CITY OF ALBUQUERQUE PLANNING DEPARTMENT January 21, 2015 DRB Comments

PROJECT # 1004245

APPLICATION # 14-70220/ 70221

RE: Blocks 7 – 9, 12 & 14, PARADISE HEIGHTS UNIT 5

CITY OF ALBUQUERQUE PUBLIC WORKS DEPARTMENT	
TITLE: ANASAZI RIDGE UNIT 3 GRADING AND DRAINAGE PLAN	
DESIGN REVIEW COMMITTEE	CITY ENGINEER APPROVAL
MO./DAY/YR.	MO./DAY/YR.
LAST DESIGN UPDATE	
CITY PROJECT NO. XXXXXX	ZONE MAP NO. A-10-Z
SHEET 1	OF 2

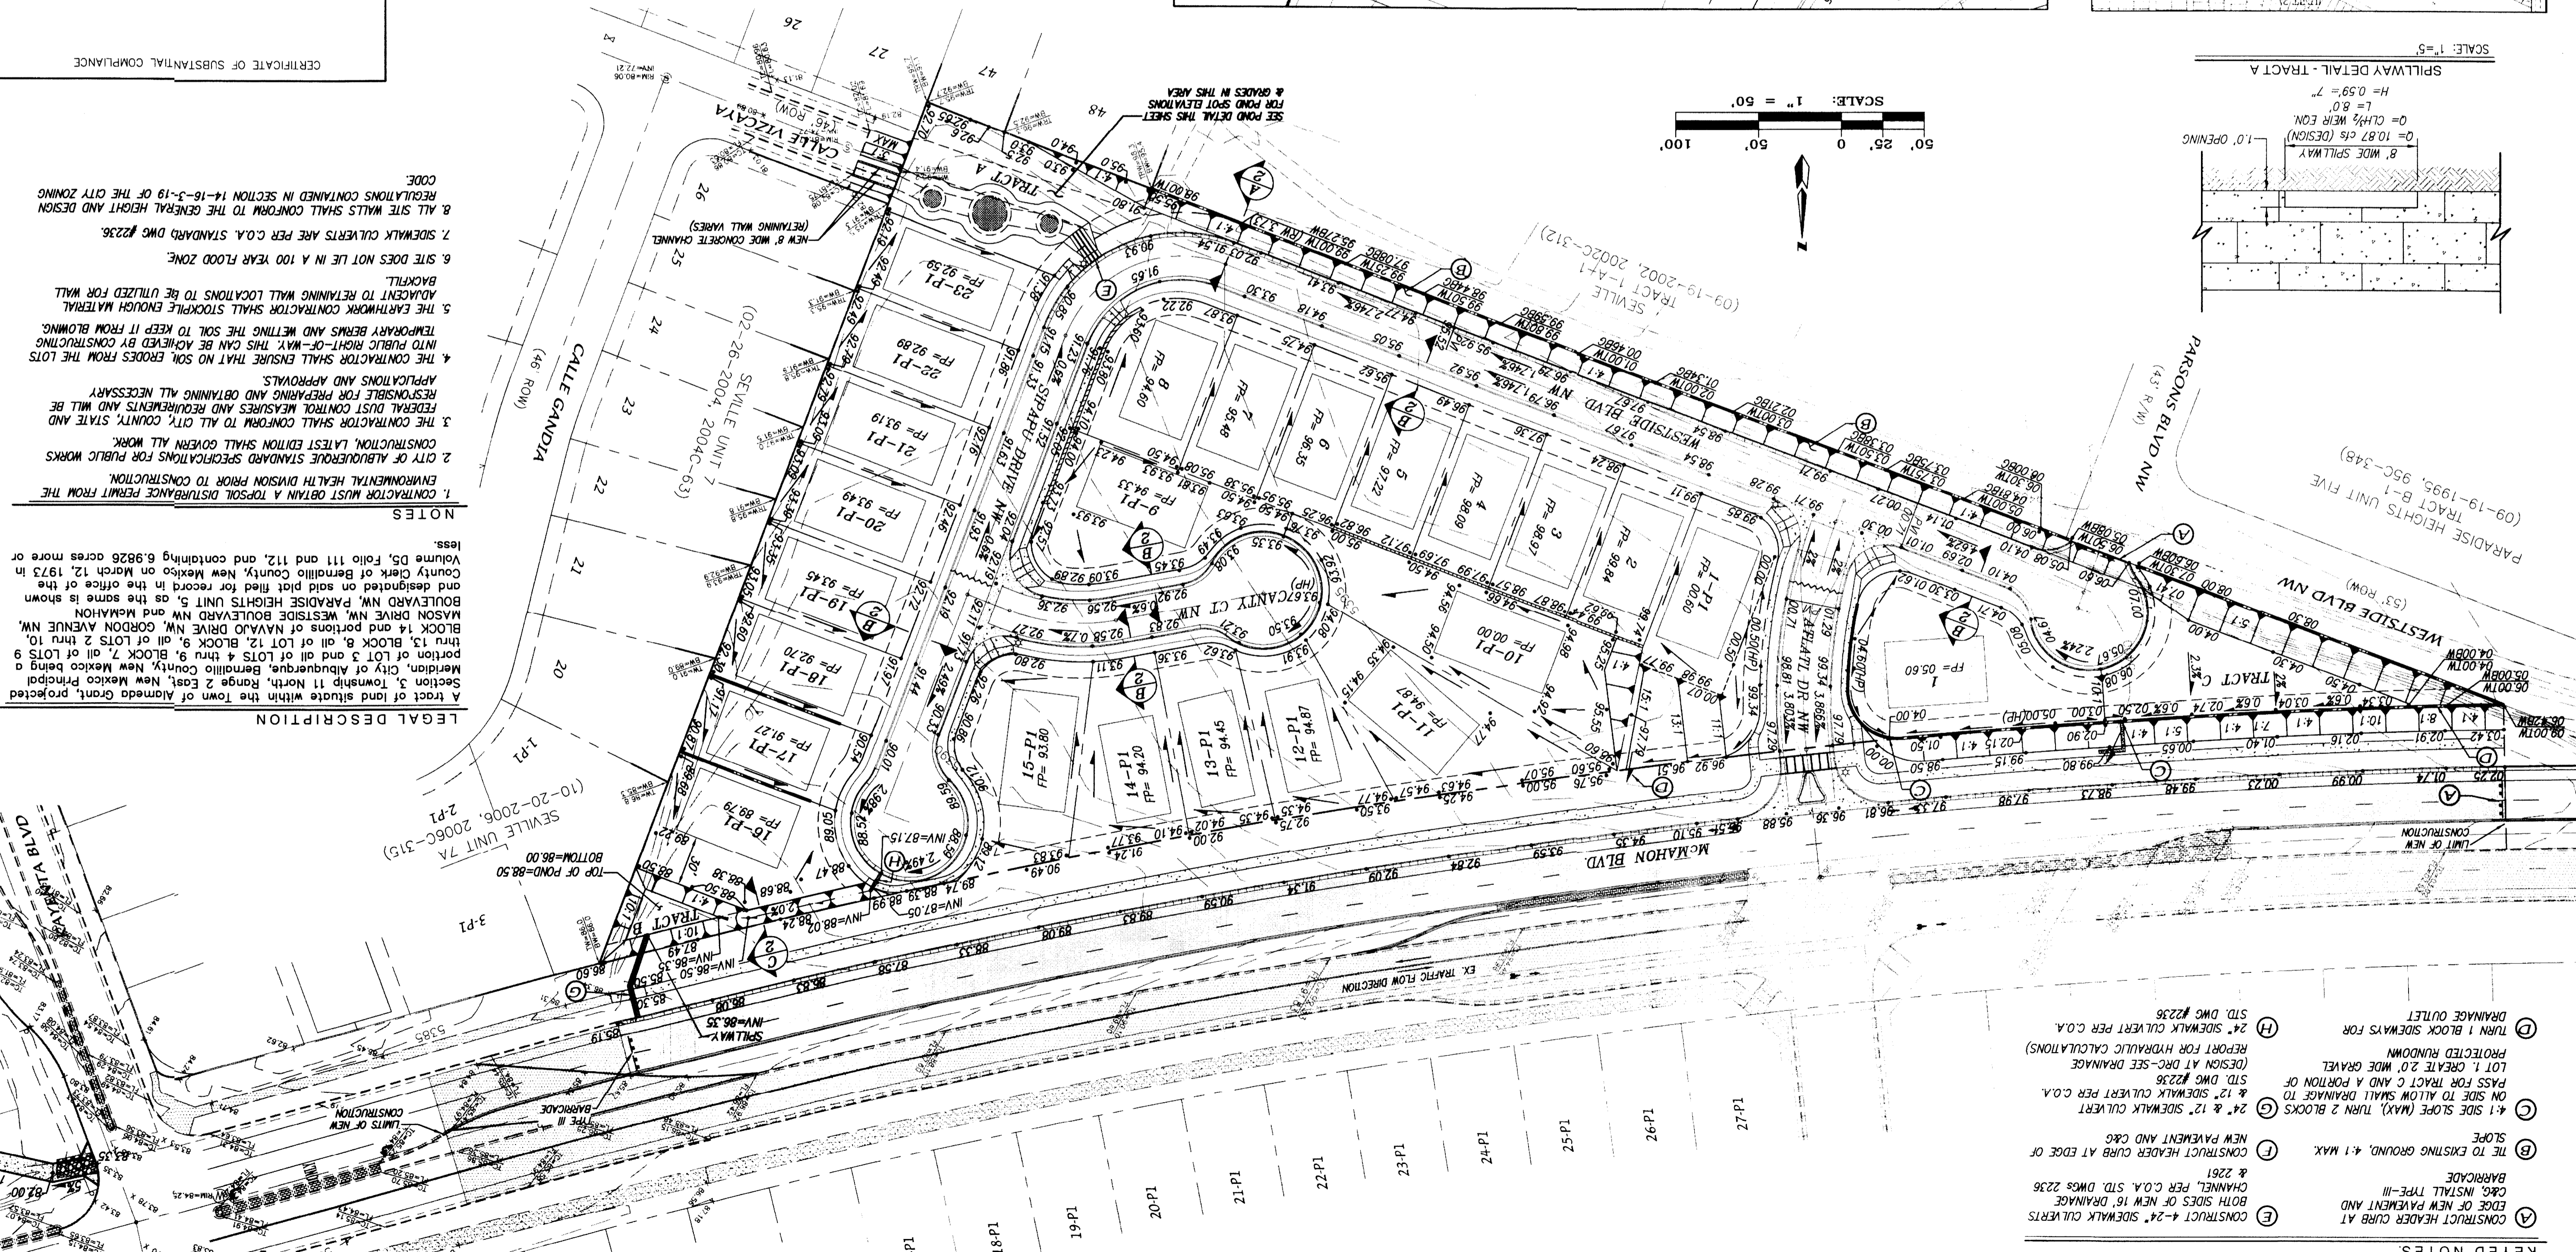
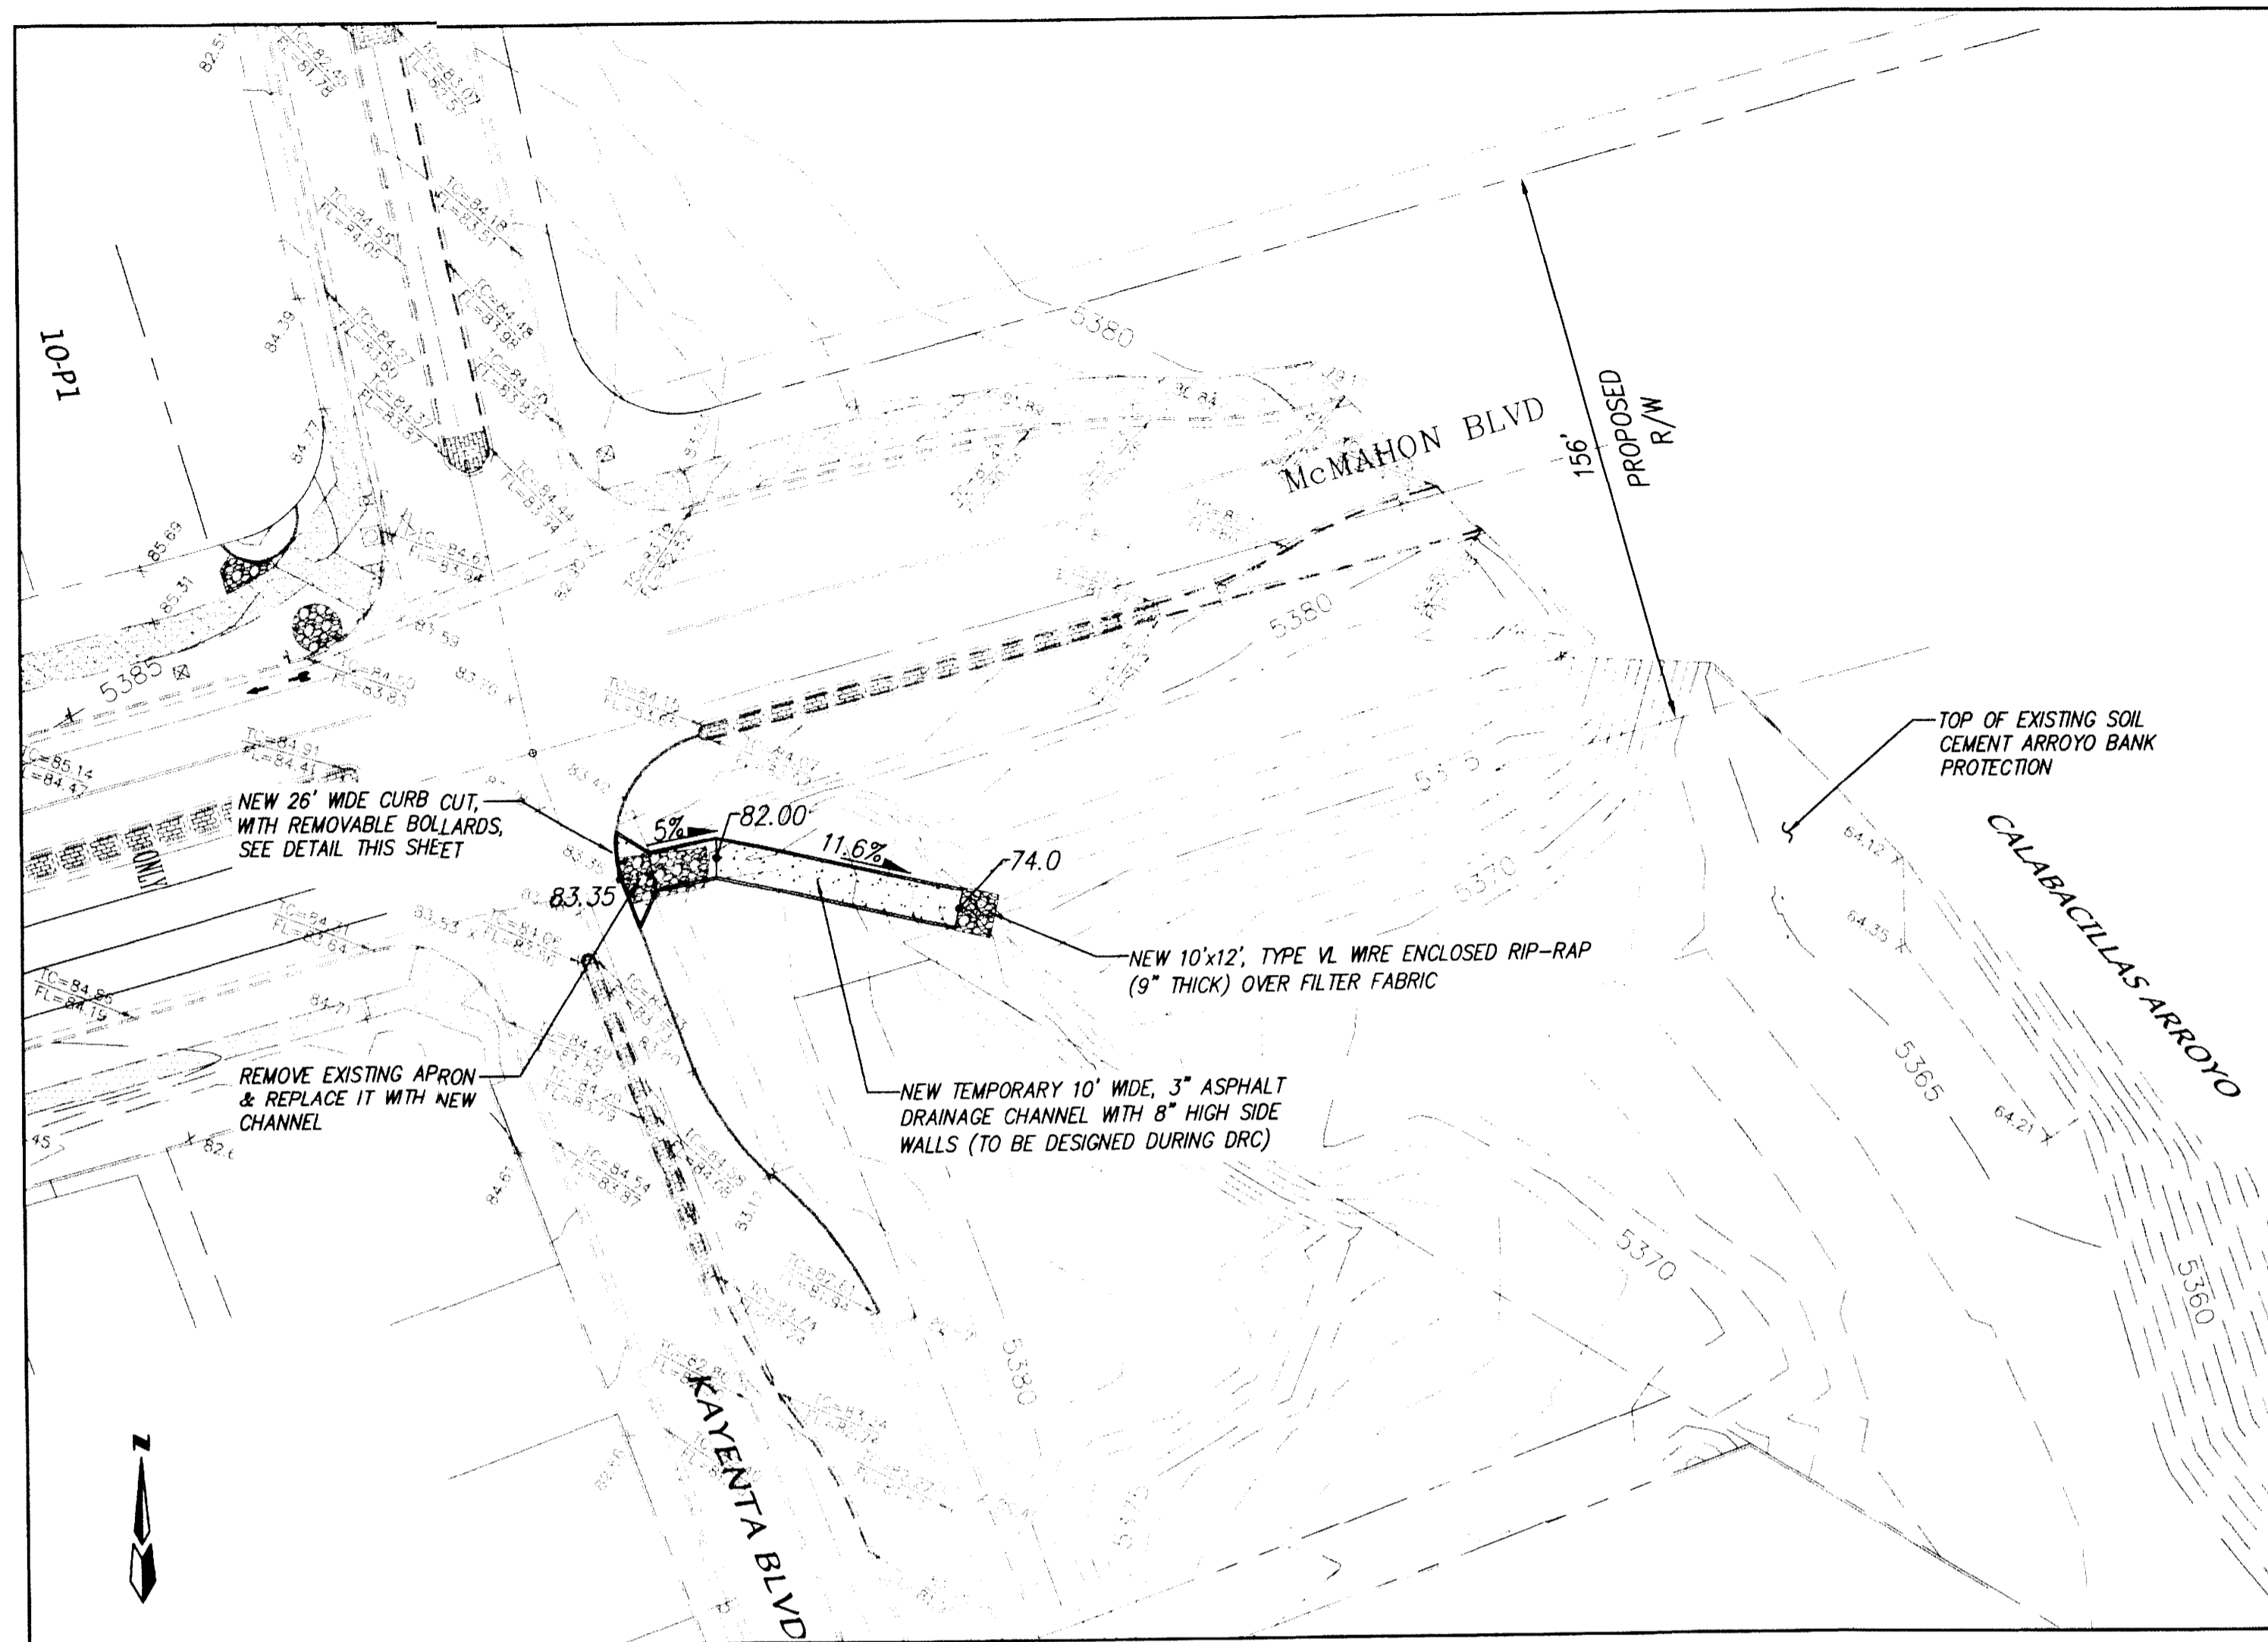
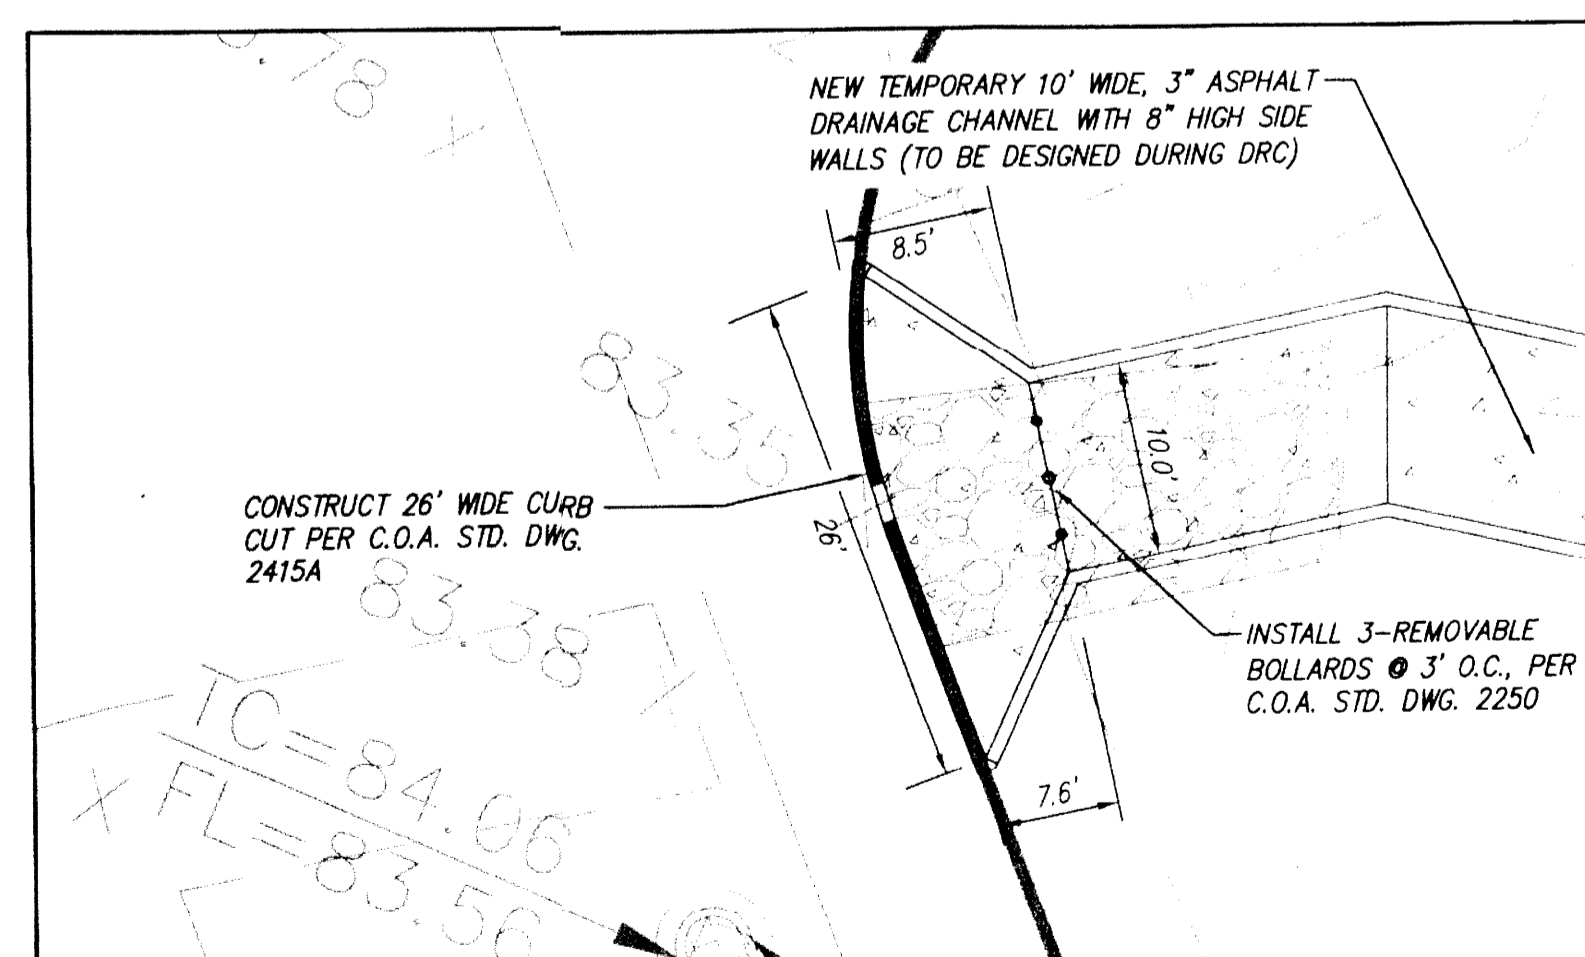
An approved Grading & Drainage Plan is required concurrent with Preliminary Plat approval; more information is needed regarding 'new' spillway in Calle Vizcaya vs. existing spillway.

SKETCH PLAT
ANASAZI RIDGE UNIT 3
 WITHIN THE
 TOWN OF ALAMEDA GRANT
 PROJECTED SECTION 3
 TOWNSHIP 11 NORTH, RANGE 2 EAST, NMPM
 CITY OF ALBUQUERQUE
 BERNALILLO COUNTY, NEW MEXICO
 OCTOBER, 2013

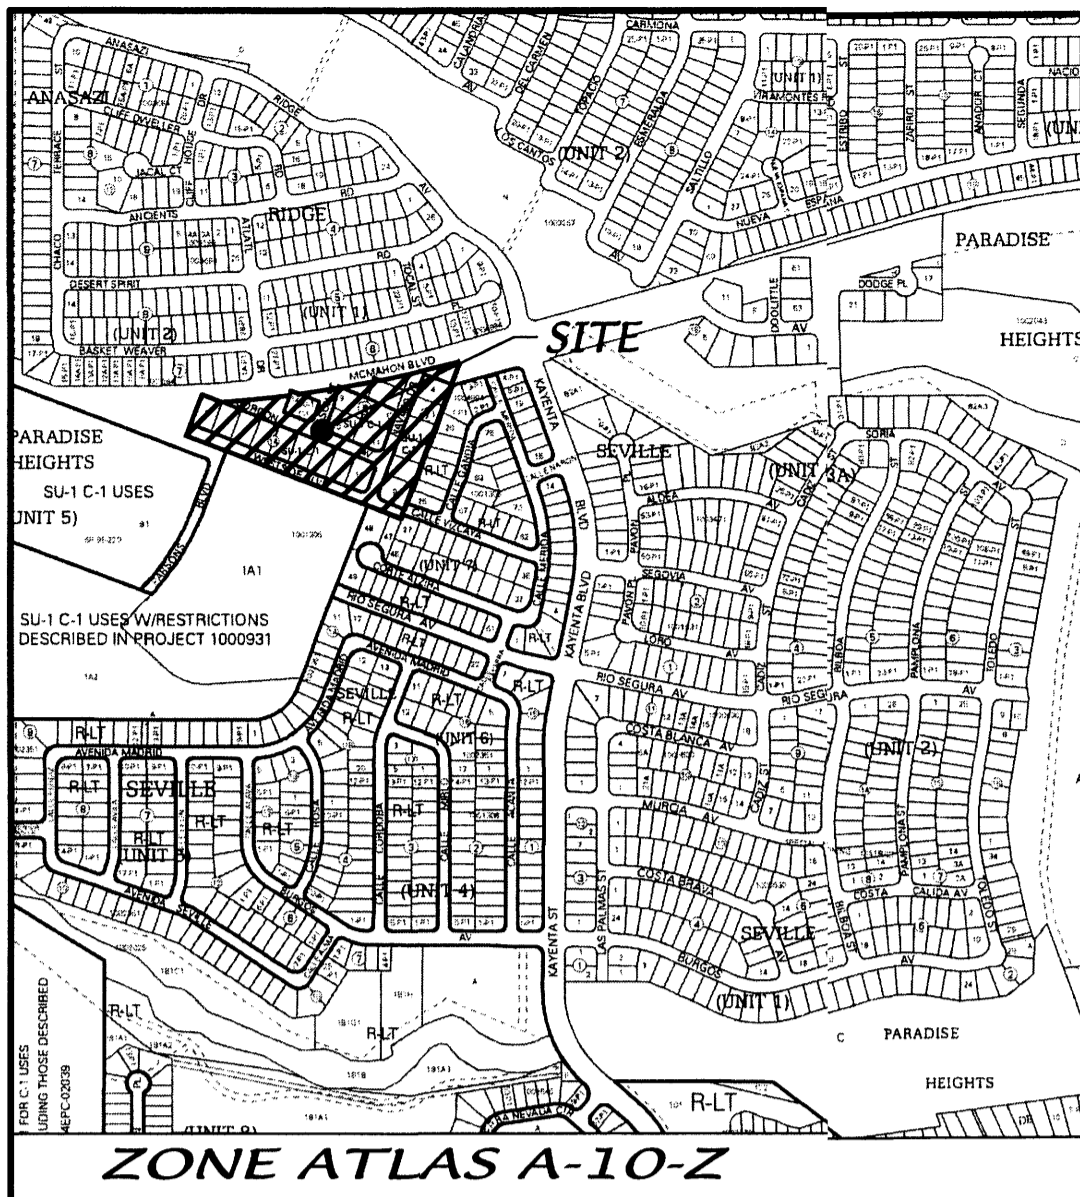
AGIS and the Planning Dept Case Tracking indicate that the 2005 zone change was completed – a zone change or an R-1 Zoning Certificate will be required.

Vacations of right of way will be required; it appears the connection of Westside and Parsons will need to be maintained in some fashion – refer to comments from Transportation Development.
